## **\*PRE-HEARING STAFF ANALYSIS\***

### **Rezoning Petition No. 2005 - 140**

**Petitioner:** The Boulevard 2000 LLC

**Request:** R-3, single-family to UR-2(CD), urban residential conditional district.

TECHNICAL DATA SHEET

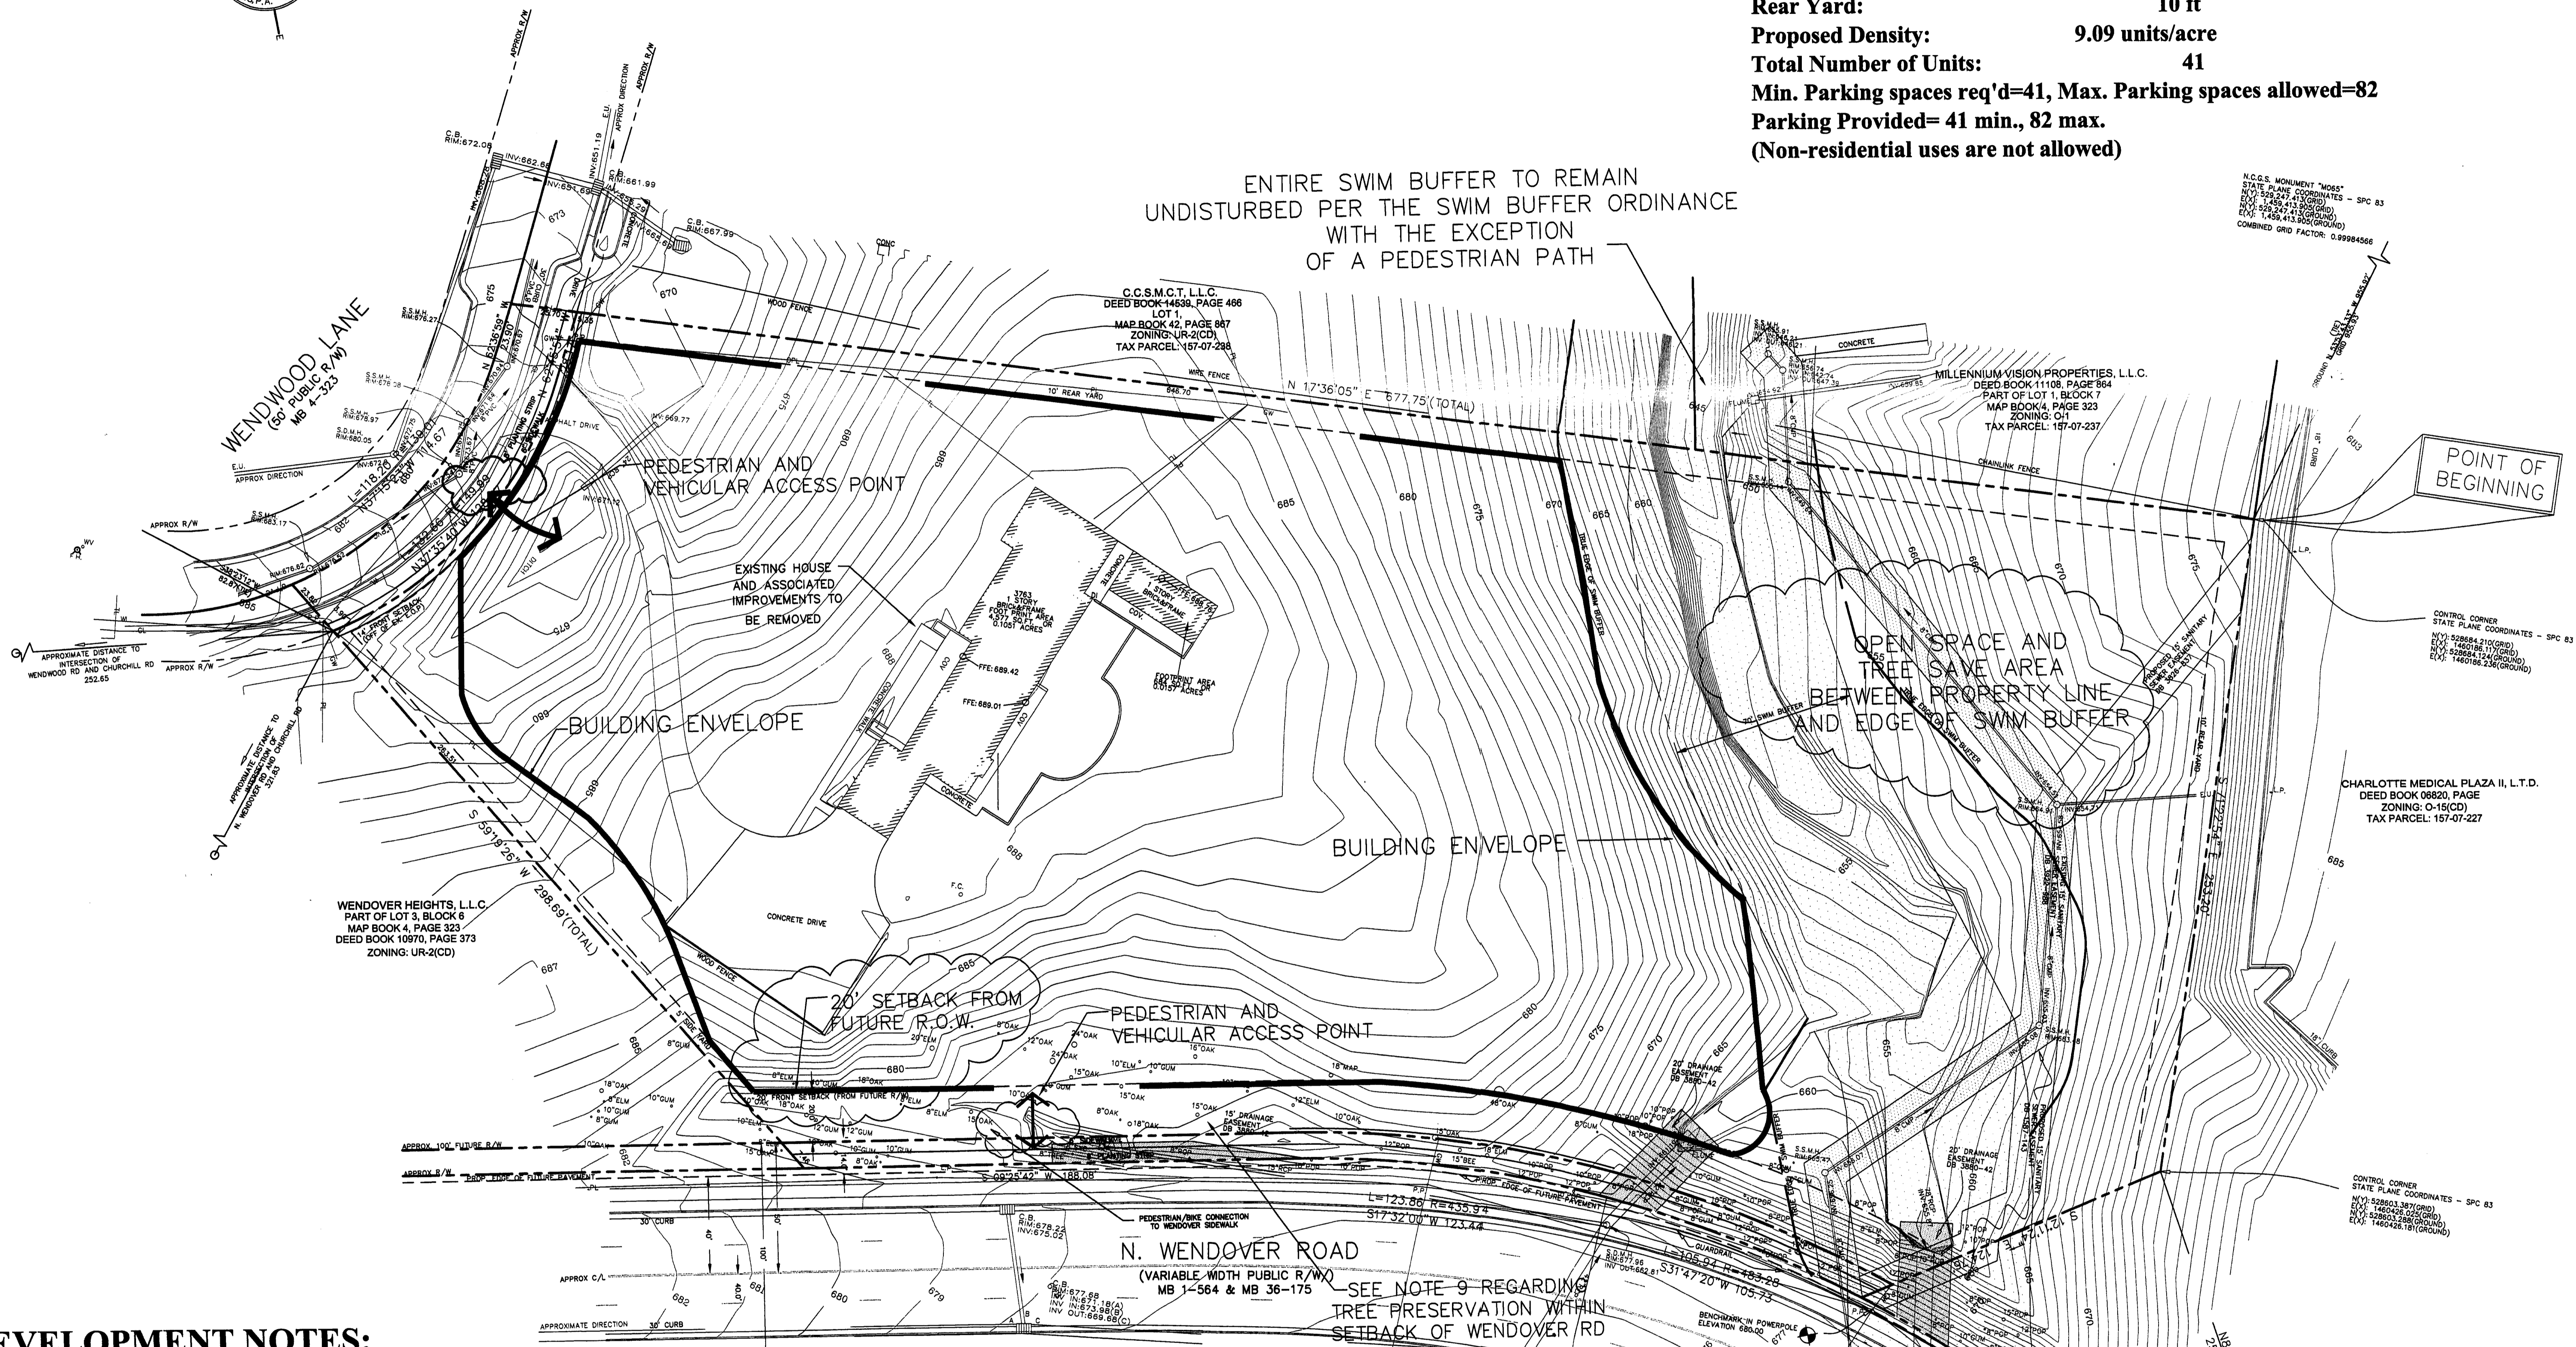
- The petitioner should note on the site plan that additional right-of-way to total fifty feet from the centerline of North Wendover Road will be dedicated and conveyed to CDOT prior to the issuance of a certificate of occupancy.

- The setback along North Wendover Road should be increased to twenty feet from the future back of curb. Currently the notes indicate a fourteen foot undisturbed setback, but it also shows a six foot wide sidewalk within the fourteen foot setback.

- A note should be added to the plan indicated that the six foot wide sidewalk may meander as long as a minimum eight foot wide planting strip is provided to save existing tree six inch in caliper and larger.

ILLUSTRATIVE PLAN

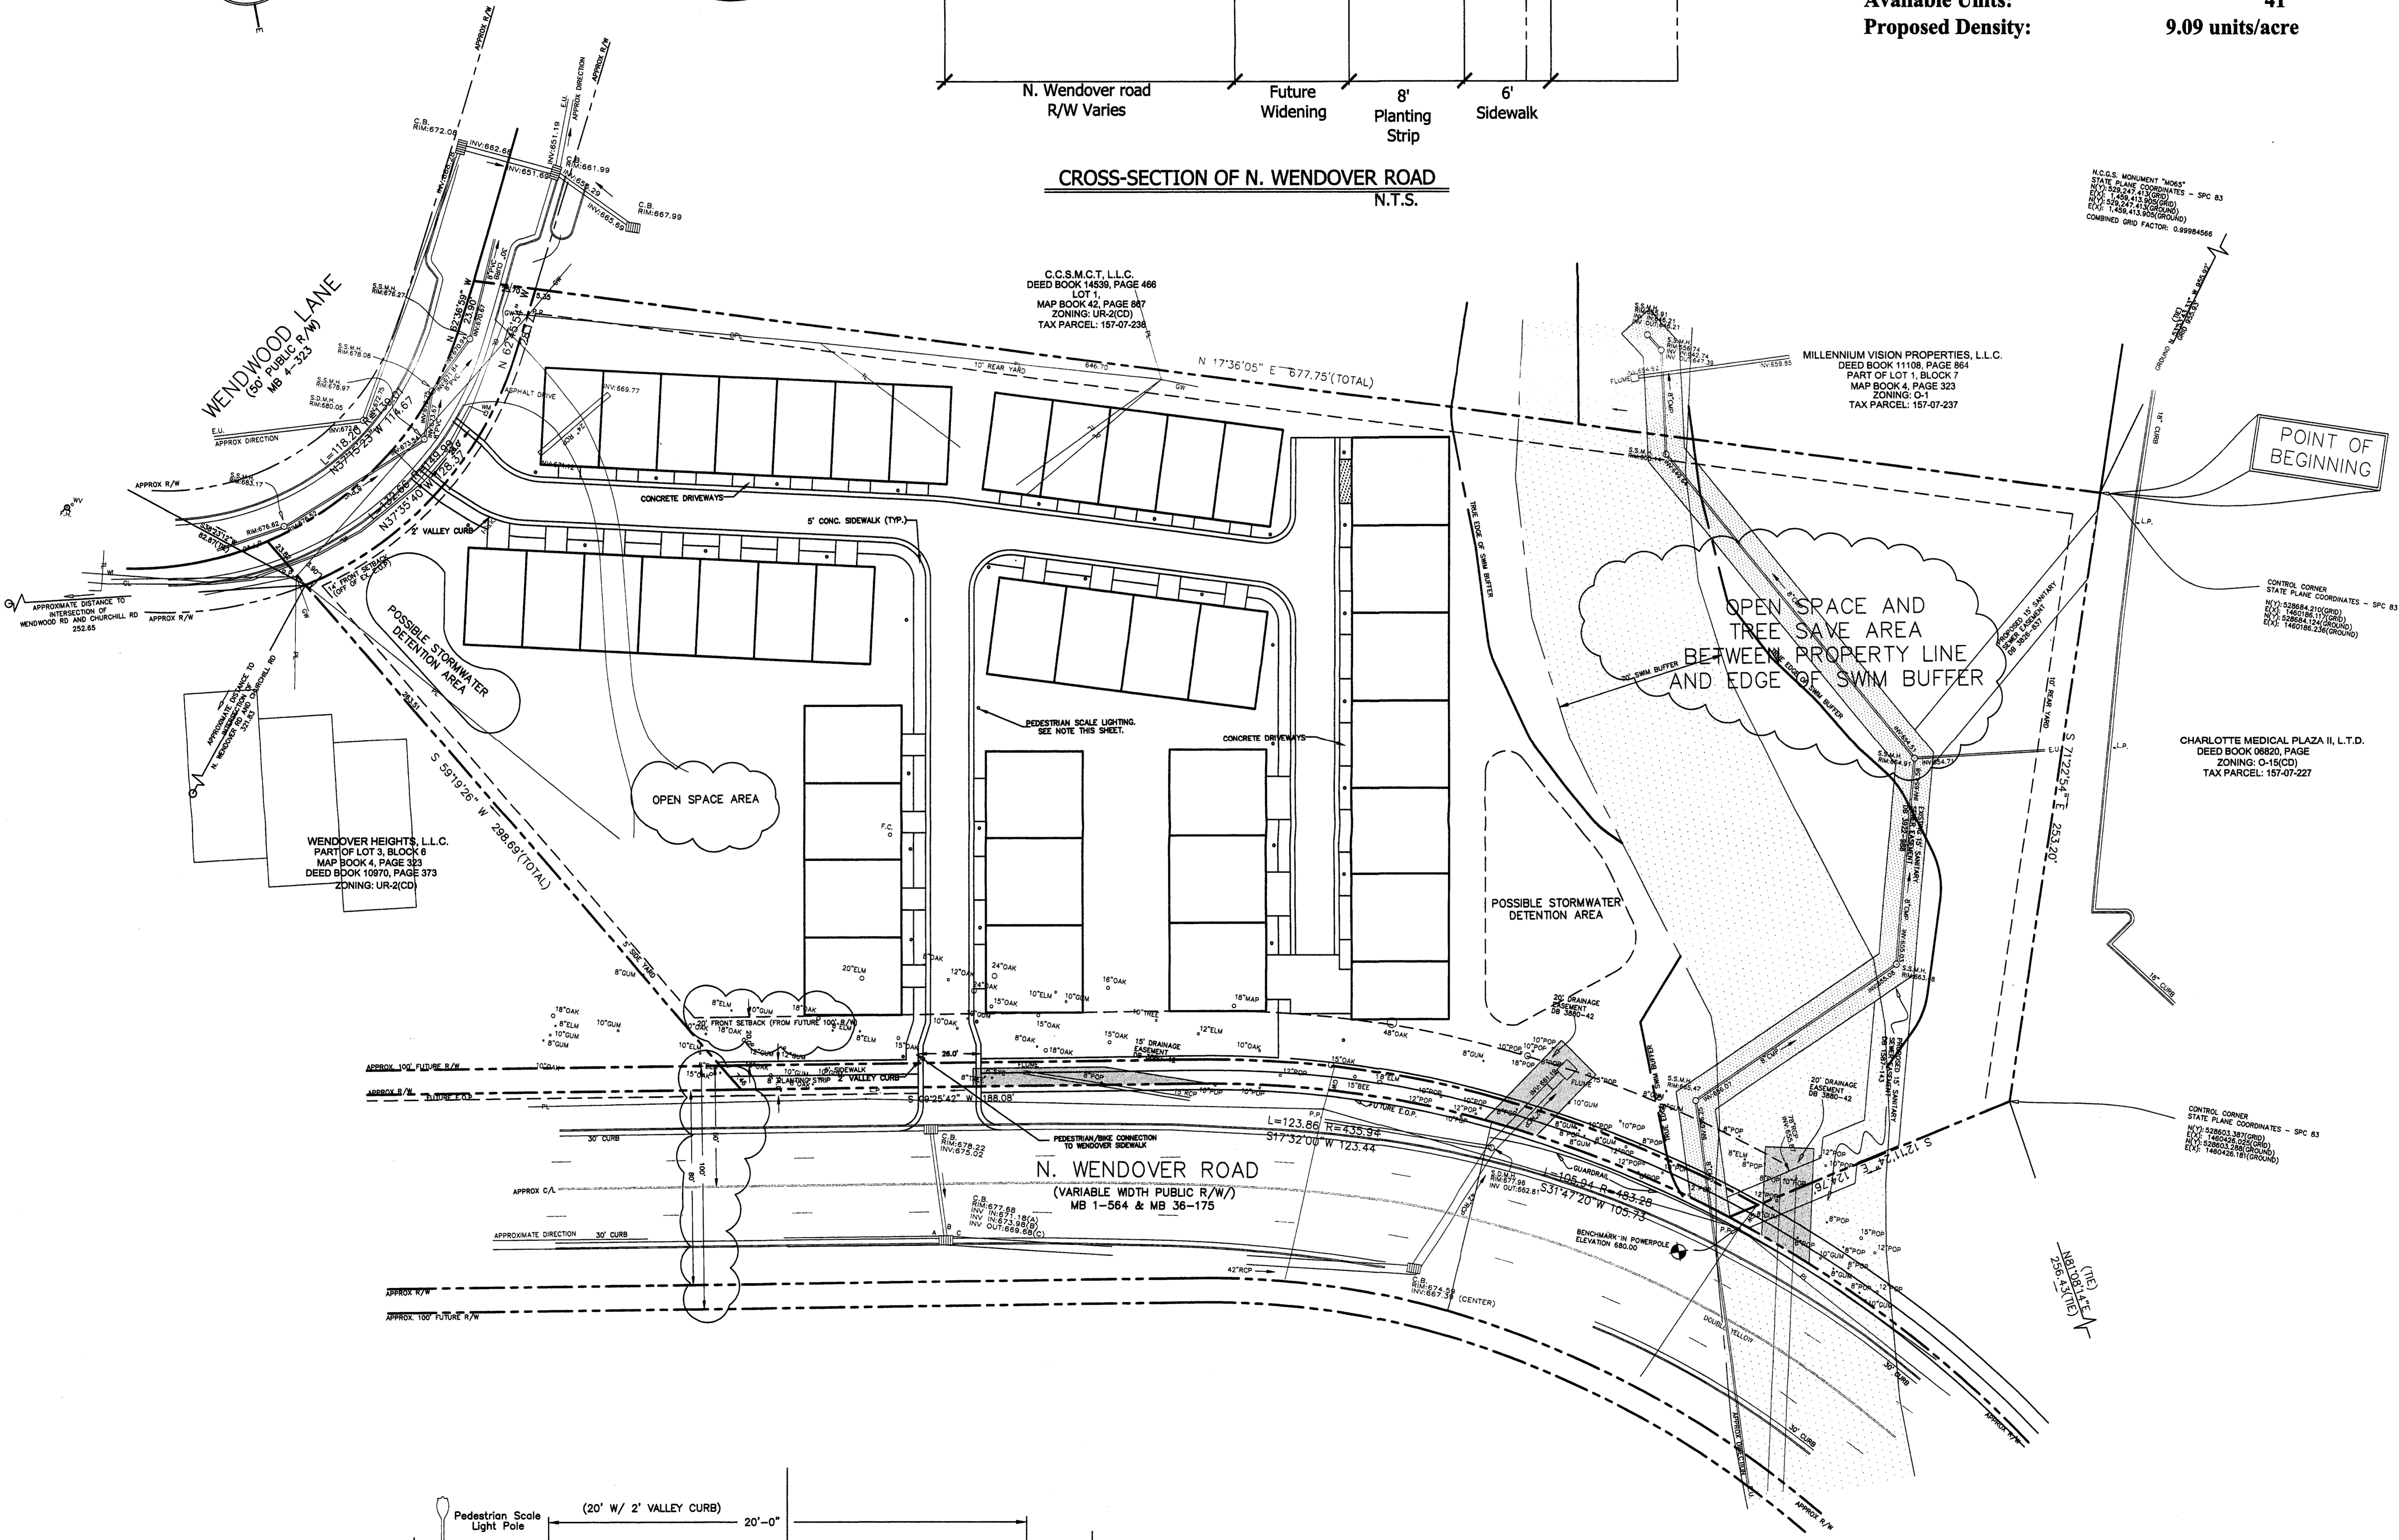
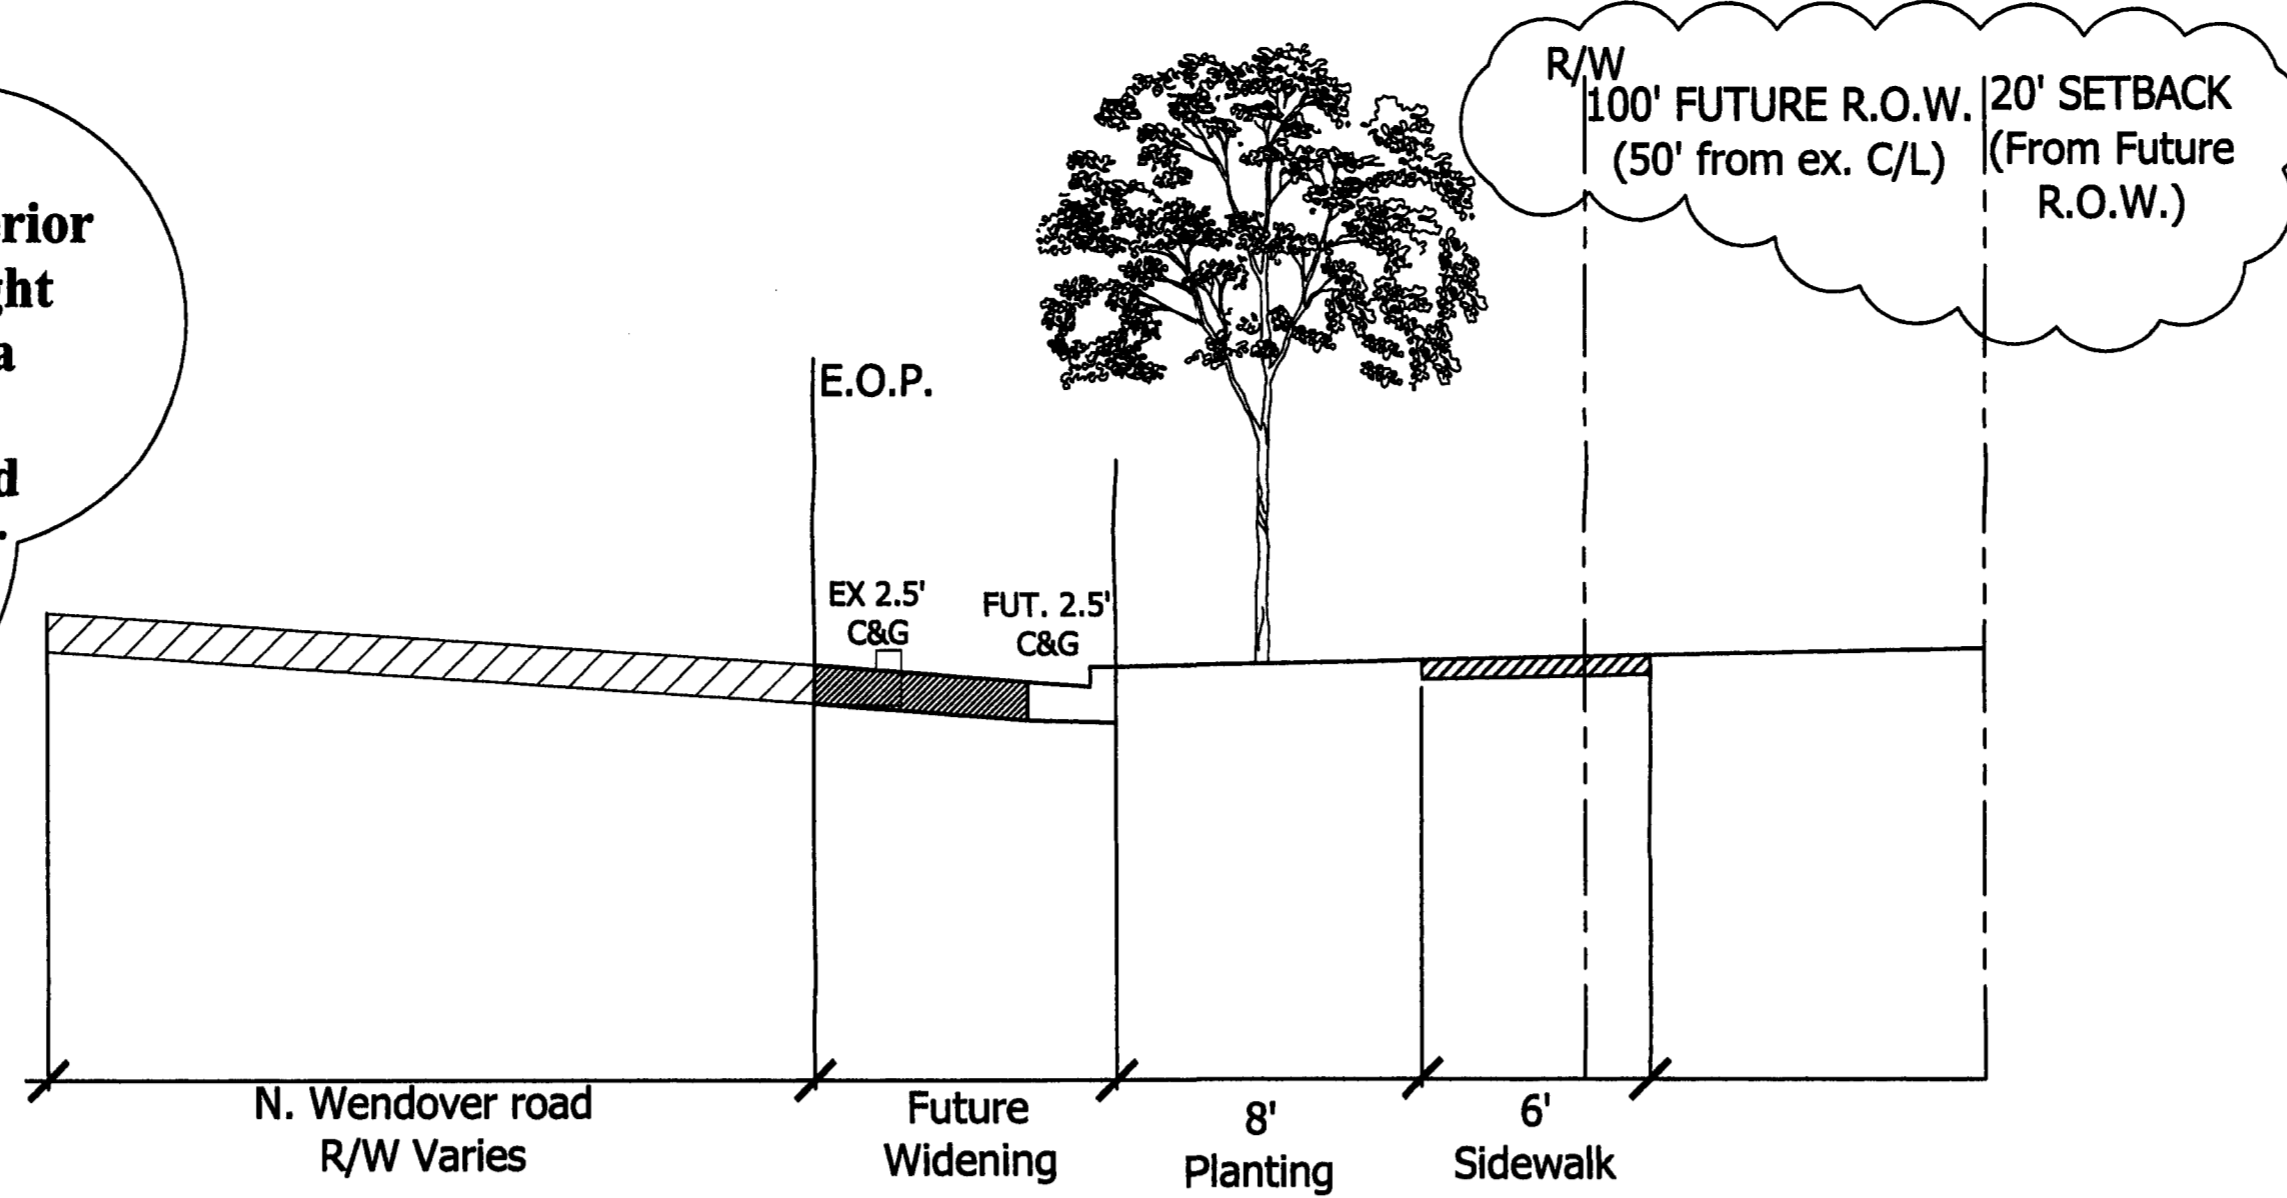
- The petitioner should include pedestrian scale lighting on all interior streets. This lighting should be shielded with full cut-off.
- Open space and tree save area locations should be shown on the plan with amenities.
